Appeal Decision

Appeal Ref: APP/R5510/D/21/3272704
30 Hillside Road, Northwood HA6 1QA

- The appeal is made under section 78 of the Town and Country Planning Act 1990 against a refusal to grant planning permission.
 - The appeal is made by Mr. Neal Daniel against the decision of the Council of the London Borough of Hillingdon.
 - The application Ref: 33702/APP/2020/4204, dated 17 December 2020, was refused by notice dated 11 February 2021.
 - The development proposed is a garage conversion into a habitable space, erection of a single storey side, part front and rear extension and loft conversion with a front dormer.
-

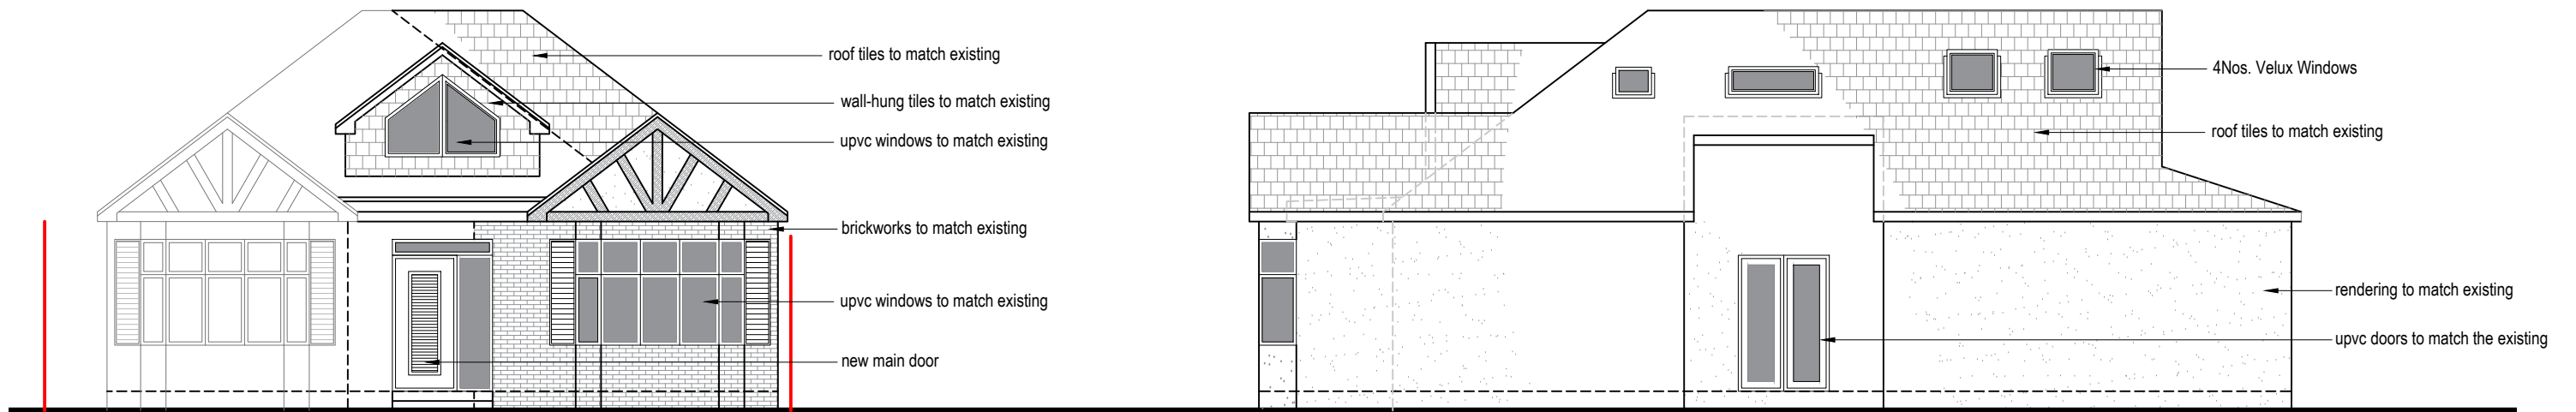
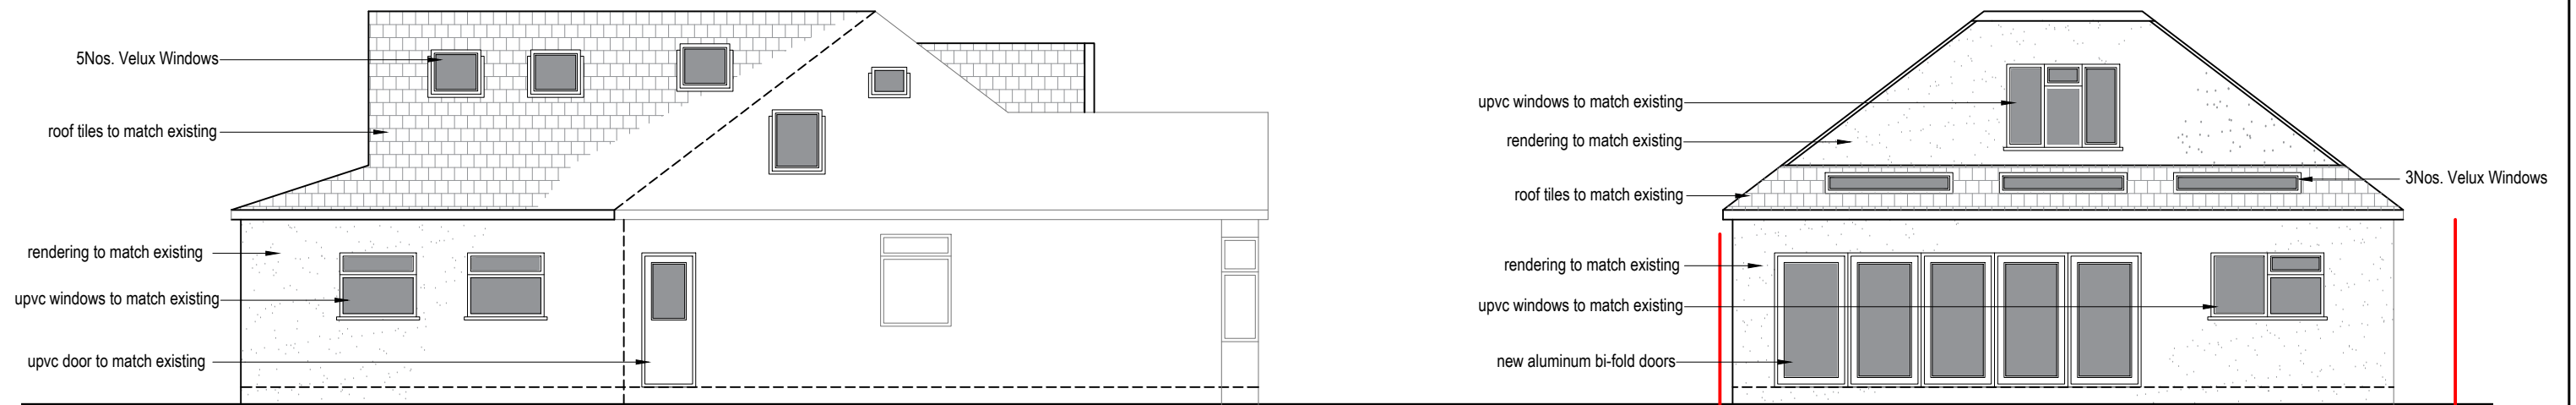
6. When taken together, the proposed extensions would significantly enlarge the size of the appeal property. A resultant effect would be the roof form. The current modest crown would be notably extended so that a larger roof would be formed. In addition, there would be a substantial rear hip to gable conversion. The scale, bulk and massing would result in the loss of much of the existing proportions and architectural composition of the bungalow, as well as the original roof form.

7. The alterations to the front would also be clearly evident from the streetscene and so would appear incongruous and detrimental to both the building and the area. The hipped roof form would be seen to be diluted by the size of the crown. In respect of the symmetrical appearance that would result, this is not an overall feature of the plots in the area, in particular as garages to the side of properties are not uncommon features.

8. The design of the proposed front dormer would also be out of keeping with the area because its pitched roofed form would contrast with the more archetypal small box dormers. Examples of pitched dormers are few and appear in better proportion on the front roof planes than what is envisaged by the proposal.

Title:			
Proposed Ground Floor Plan			
Scale:	1:50	Paper Size:	A3

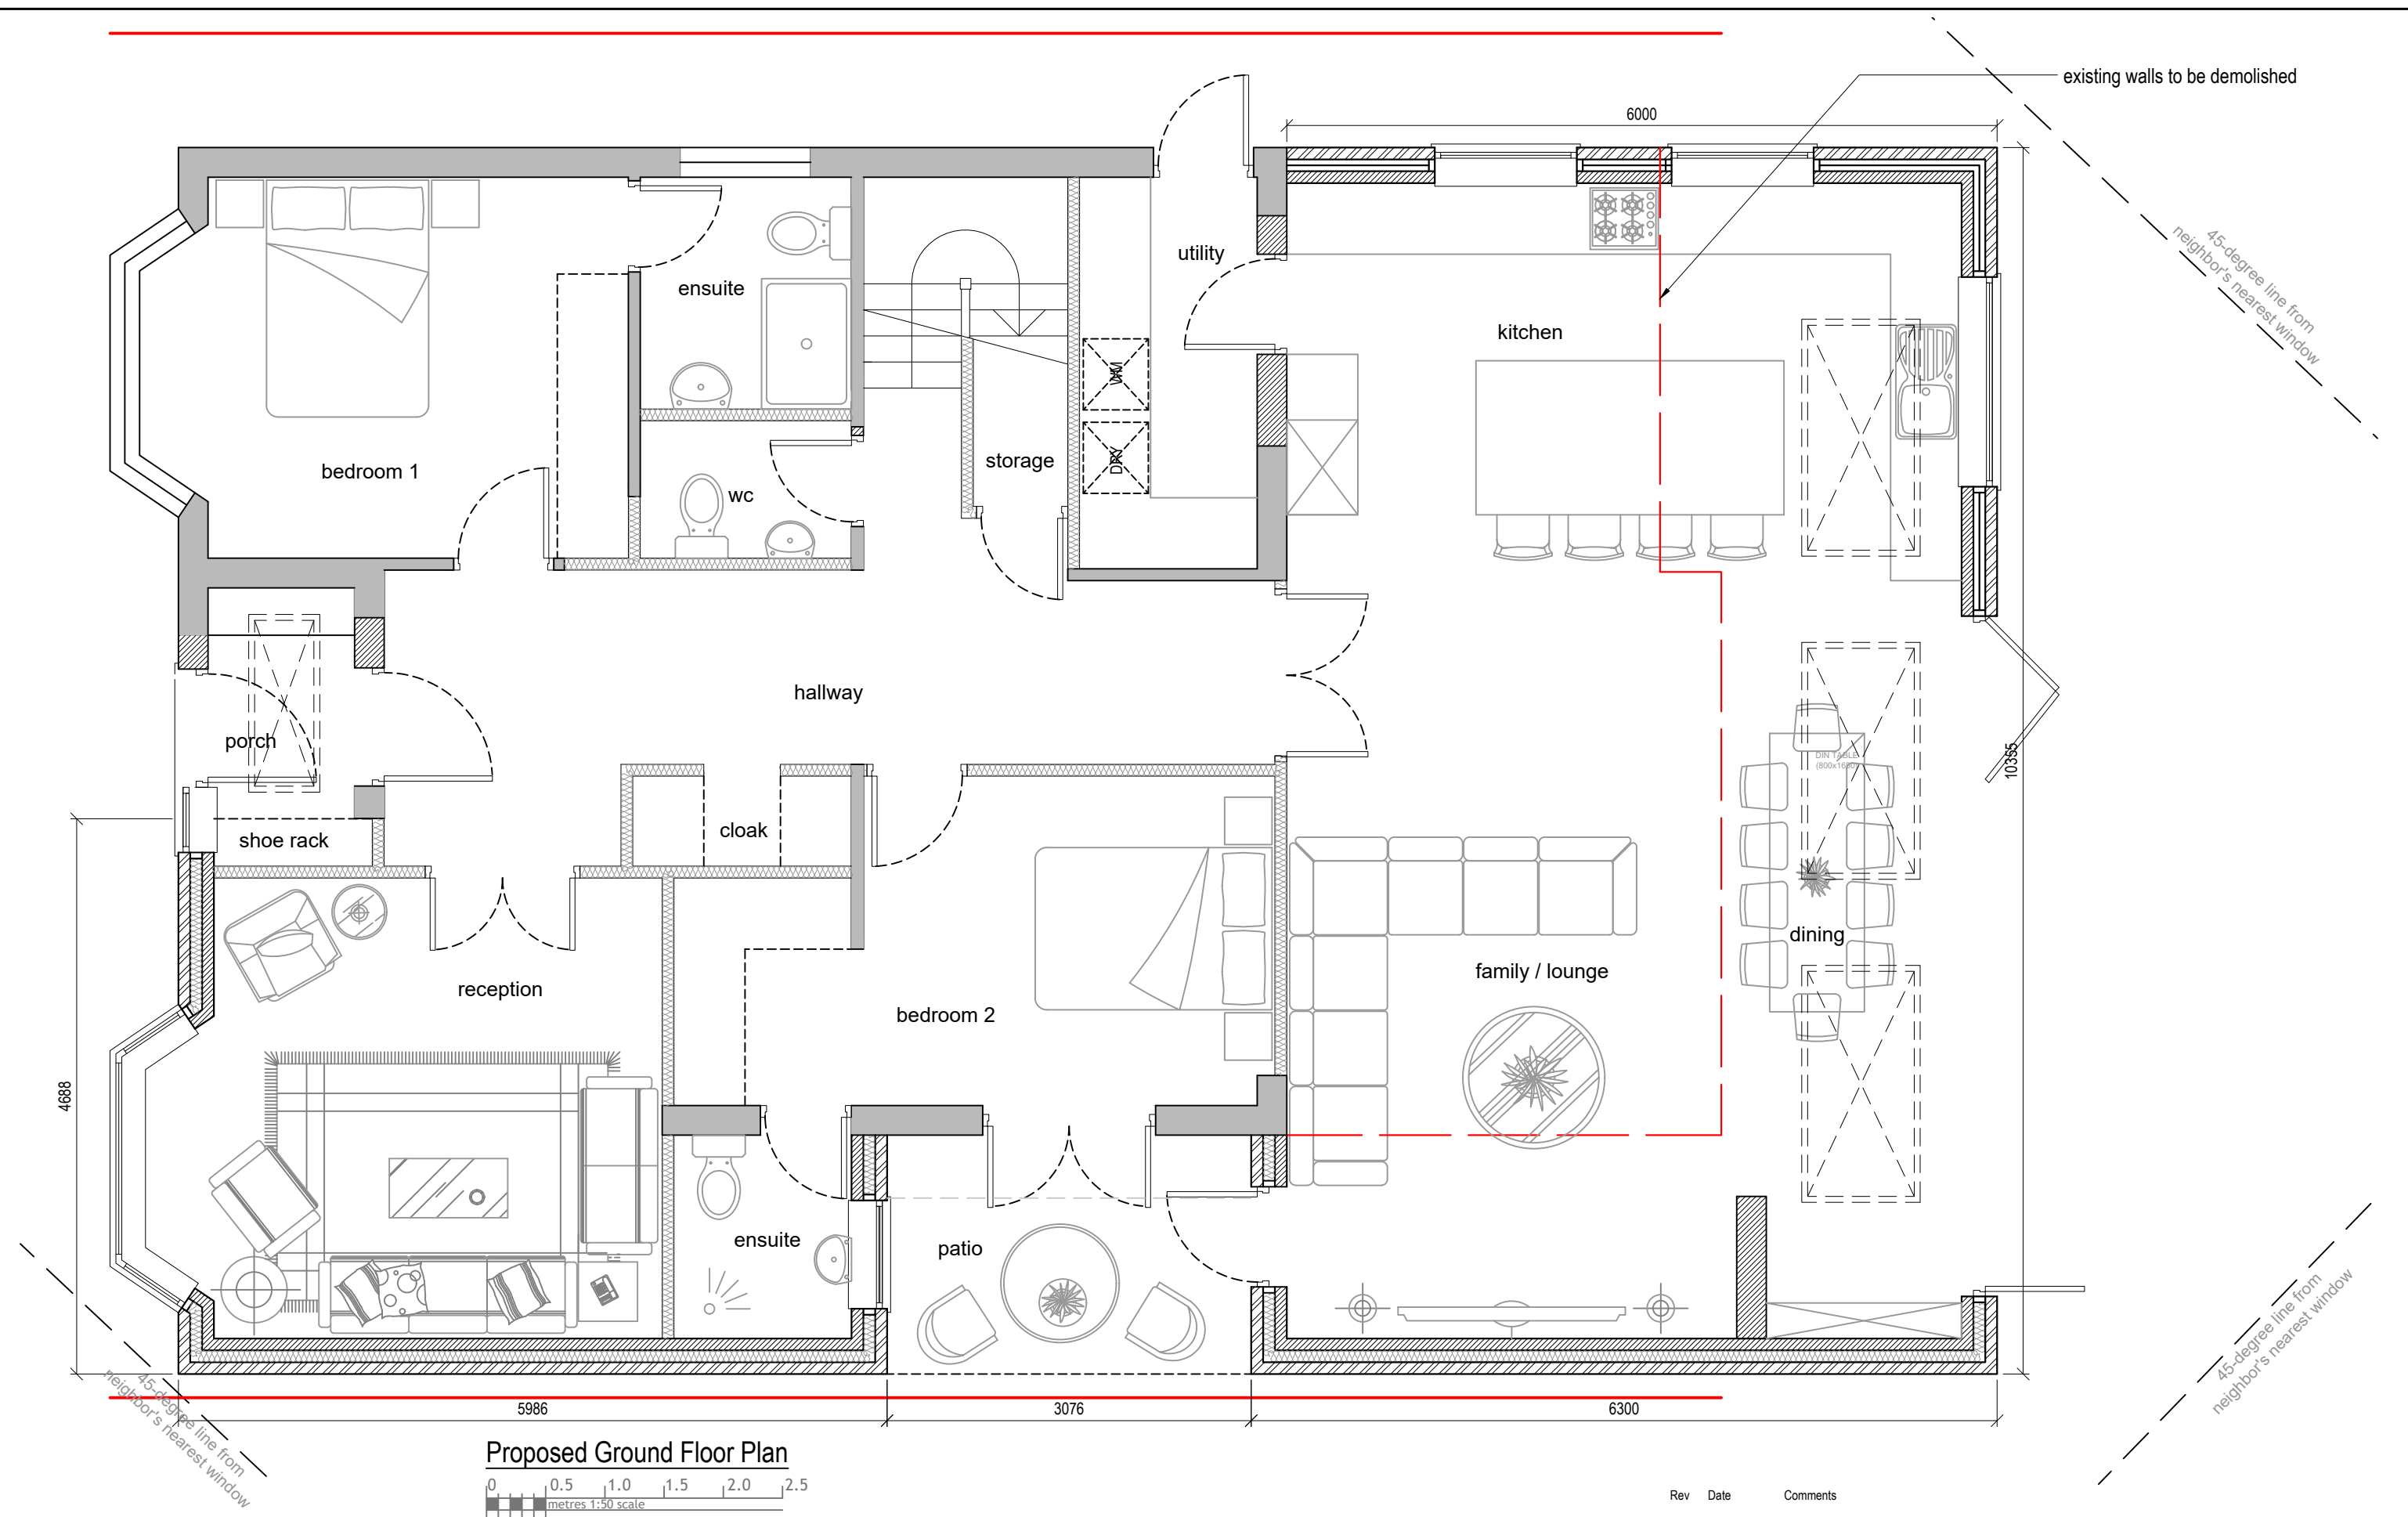
Character and Appearance

14. The proposed rear extension would maintain the same distance to the boundary as the existing house. Whilst it would project back a greater distance, the height of the facing side wall would not be markedly higher than the fence and the roof would then hip back further from the boundary. With this relationship to the open area to the side of No 32, it would not result in an undue sense of enclosure. Thus, the scale, bulk, height and proximity of the proposed rear extension would not be overly dominant, overbearing and imposing.

15. Whilst the overall proportions of the proposed rear extension are significant, the effect on the occupiers of No 32 would only result from the part of it nearest the boundary. For the reasons that I have set out, this would not be unacceptable. The spacing afforded by the width of the rear at No 32 would also mean that cumulative effects with that property's relationship with the rear of No 34 would also be satisfactory.
